Our Ref: A/84/17/PL
Your Ref:

Town & Country Planning Act 1990 (as amended)
Town and Country Planning (Development Management Procedure) (England) Order 2015
Application for Planning Permission

Development New retail unit with mezzanine together with associated car parking & service road -
This is a Departure from the Development Plan

Location Rustington Golf Centre Golfers Lane Angmering

East Elevation

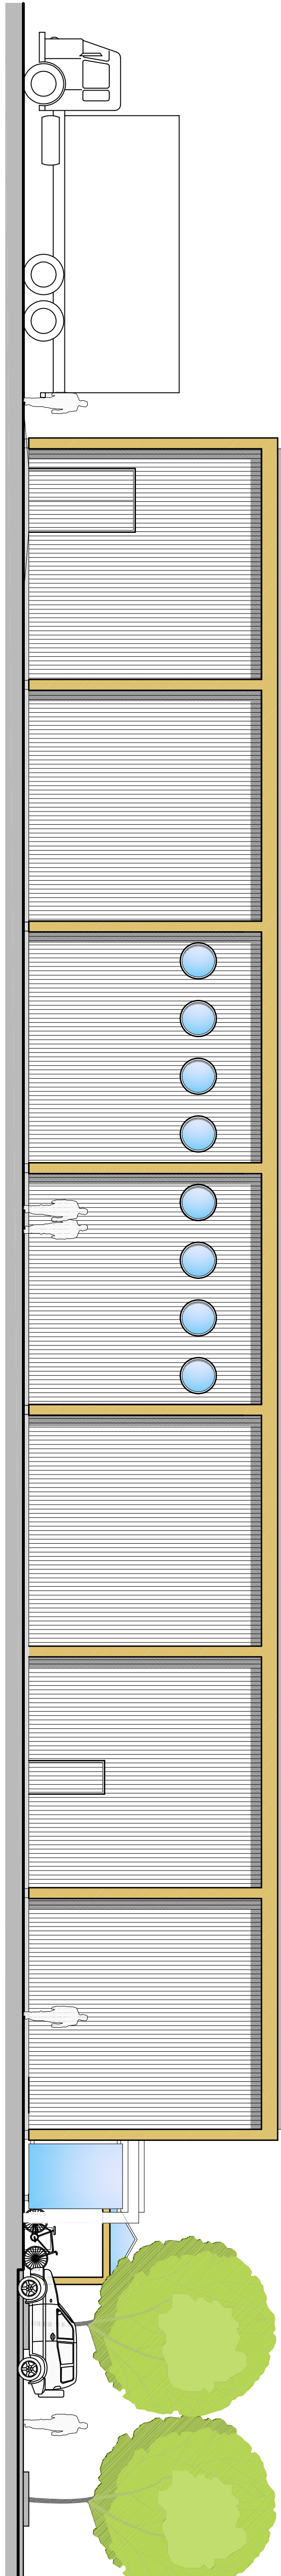
Drawing no 16-16002-PL14 - East elevation is not showing the entrance doors
